WEST SUSSEX COUNTY COUNCIL CONSULTATION

TO:	Arun District Council FAO: Mr S. Davis
FROM:	Highways, WSCC
DATE:	18/02/2025
LOCATION:	Land at Stoney Brook Farm, Eastergate Lane, Walberton, BN18 0BA
SUBJECT:	WA/9/25/PIP Application for permission in principle for the maximum erection of 2 No self build dwellings.
DATE OF SITE VISIT:	N/A
RECOMMENDATION:	Advice
S106 CONTRIBUTION TOTAL:	£N/A

PROPOSED DEVELOPMENT
 Stoney Brook Farm, Eastergate Lane
 Arundel, BN18 0BA
 Scale 1:1000 (A4)
4470-04

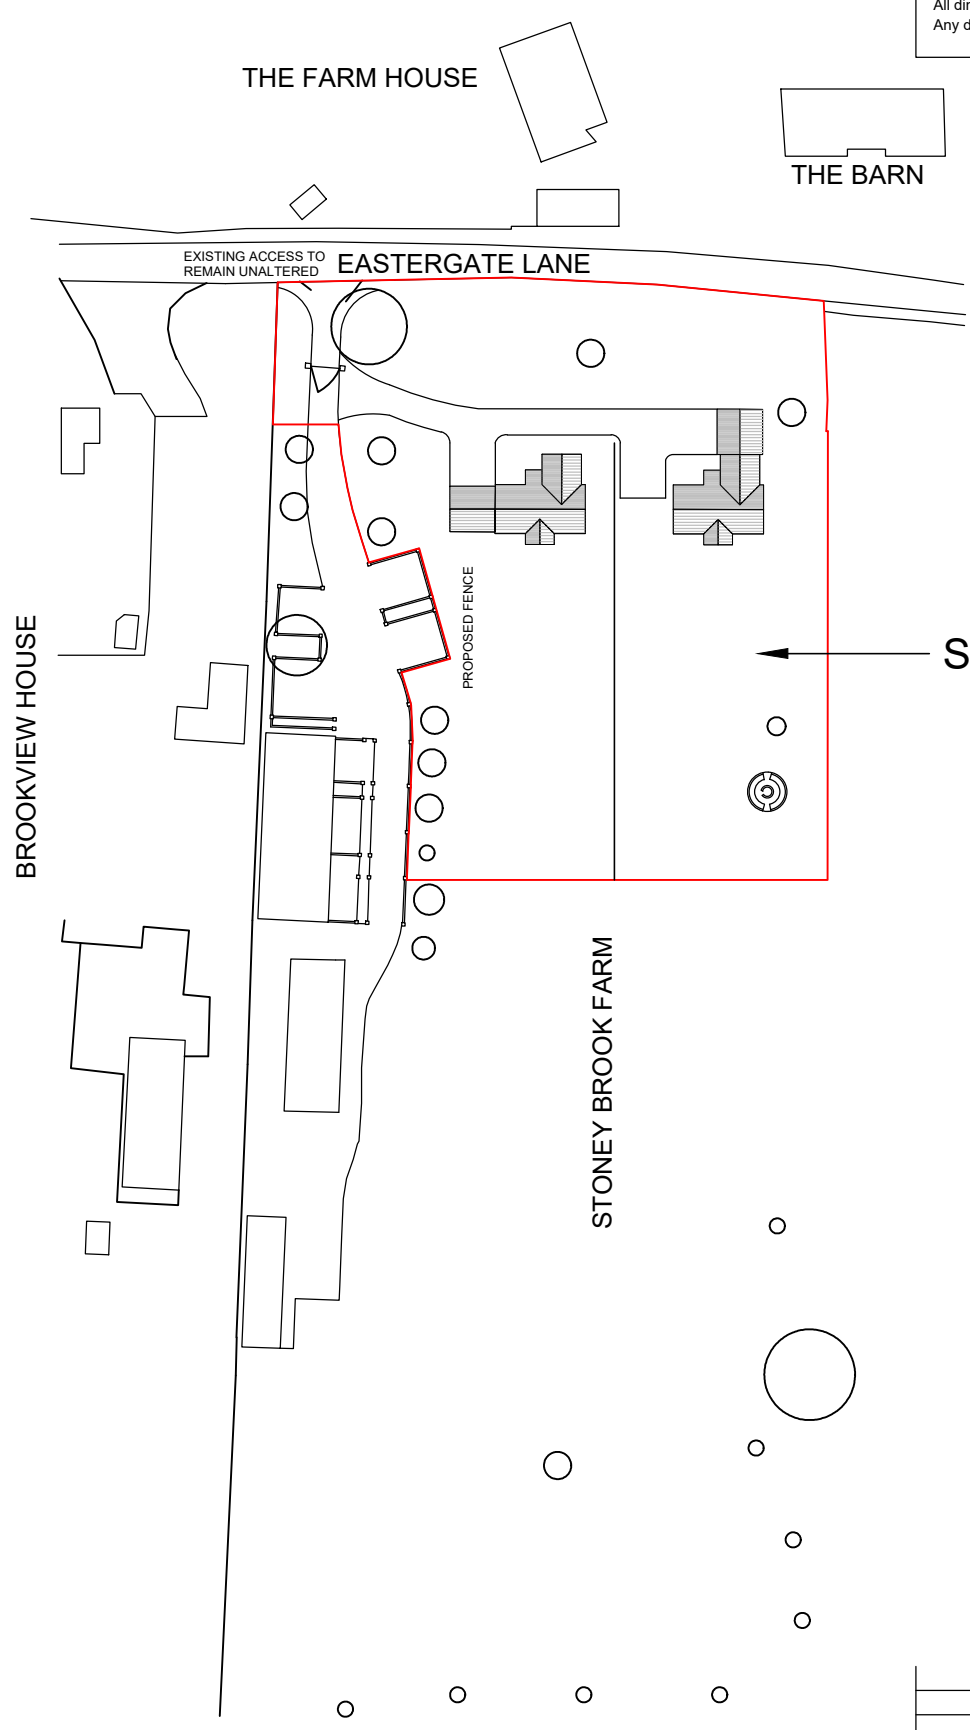
The indicative plans suggest that the existing vehicular access will be utilised to serve the site, with no alterations proposed. From inspection of WSCC mapping, visibility at the access point onto the public highway appears sufficient for the anticipated road speeds in this location. The addition of two dwellings is not anticipated to give rise to a significant material intensification of use of the existing access point.

As per the application type, details have not been provided in regards to dwelling size (number of bedrooms), or parking provision. At Technical Details Consent stage, the LHA would expect details to be provided demonstrating proposed vehicular access arrangements to the site, sufficient space for parking and turning of vehicles in accordance with Arun Parking Standards. Sufficient secure and covered cycle storage should also be demonstrated, to encourage sustainable transport methods and reduce the reliance upon the private car.
